**Consultation Response from KC,
Lead Local Flood Authority**

2023/92966 Land to the rear of, 271, Cliffe Lane, Gomersal, Cleckheaton, BD19 4SB

Demolition of existing dwelling and erection of 97 dwellings including formation of a new access from Cliffe Lane, landscaping, public open space and all associated infrastructure and engineering works

Date Responded: 1st December 2024

Client	QUARTERS DEVELOPMENT		
Project	CLIFFE ROAD GOMERSALL		
Drawing title	PROPOSED LEVELS OPTION 2		
Drawn	MT	Chkd	AD
Date	JAN 23	Scale	1/250
Contract No.	22691-DR-C	Drig No.	0603-1
Revision	P2

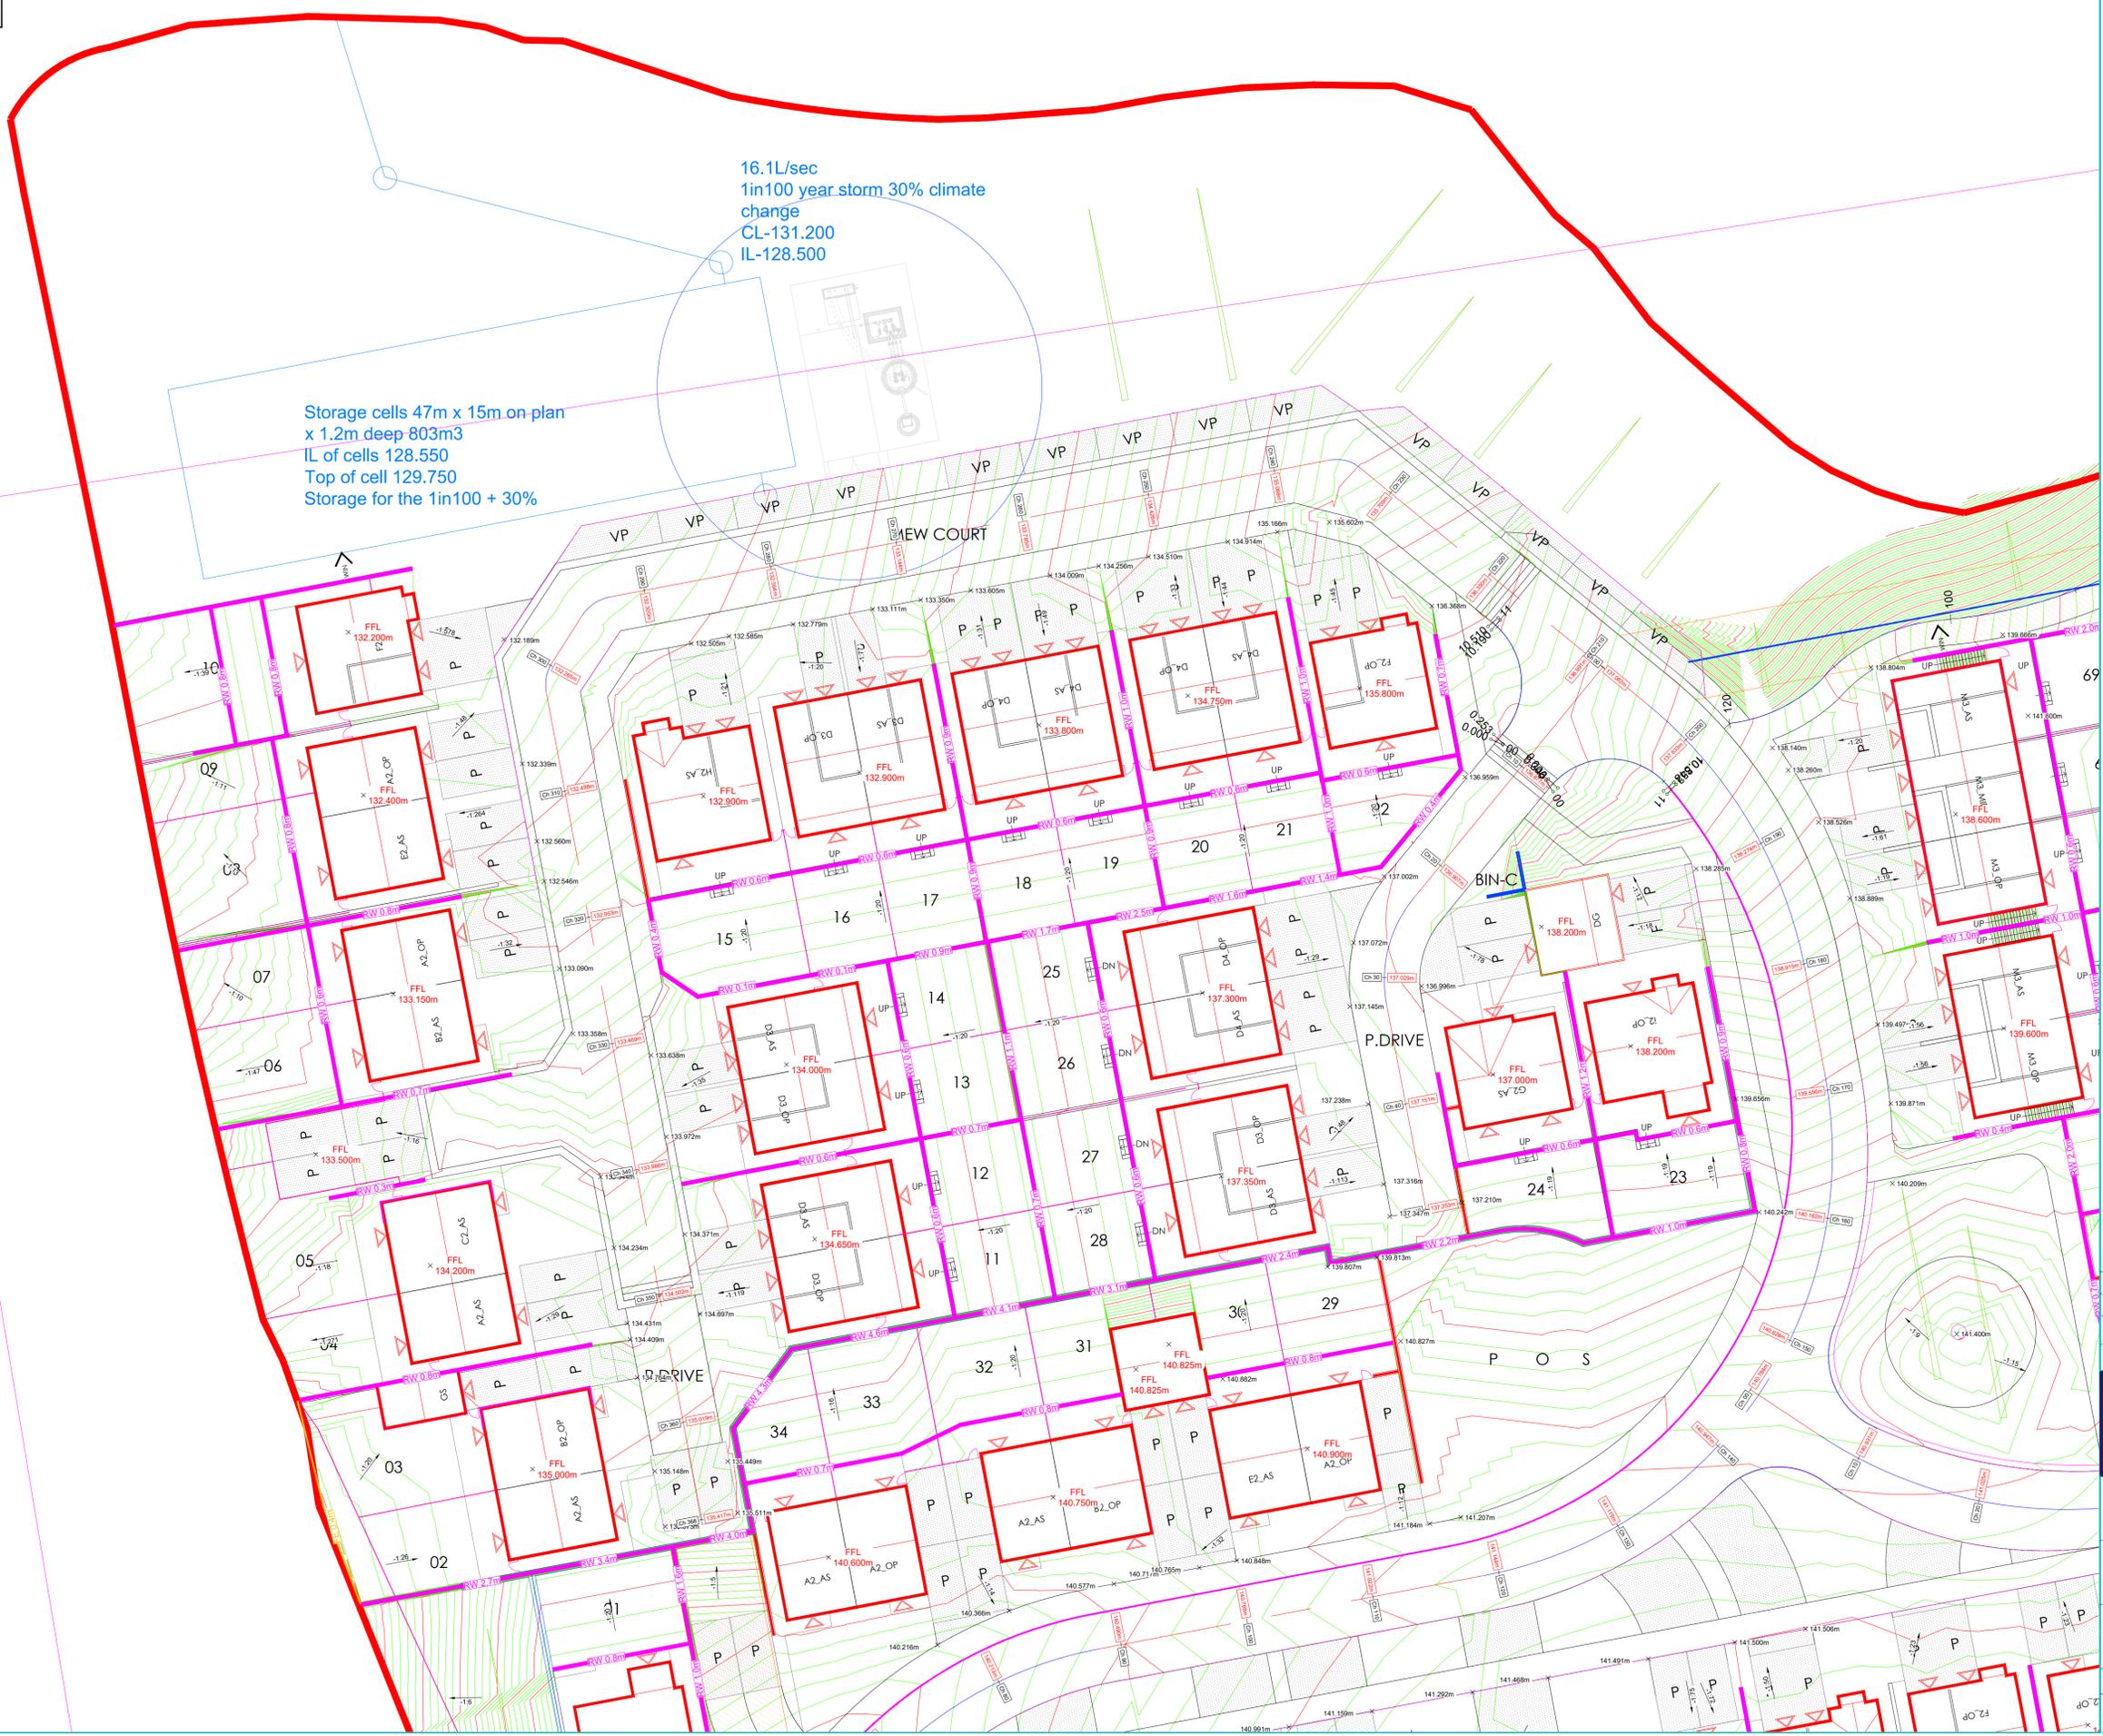
The surface water drainage strategy is accepted. Full details of the tank design can be submitted at detailed design stage with an appropriate maintenance plan. Double gullies adjacent to plot no.1 would appear to be a legacy from an older design as the flood routing plan indicates a different low spot.

Development shall not commence until a surface water attenuation scheme utilising the agreed discharge rate (16.1l/s) has been submitted to and approved in writing by Local Planning Authority. The drainage scheme shall be designed to attenuate flows generated by the critical 1 in 100-year storm with a 30% allowance for climate change. Detailed drainage design downstream of the attenuation including details of the outfall to watercourse and associated erosion control shall be submitted alongside a detailed maintenance and management regime for the storage facility including the flow restriction and outfall. There shall be no piped discharge of surface water from the development and no part of the development shall be brought into use until the flow restriction and attenuation works comprising the approved scheme have been completed. The approved maintenance and management scheme shall be implemented thereafter.
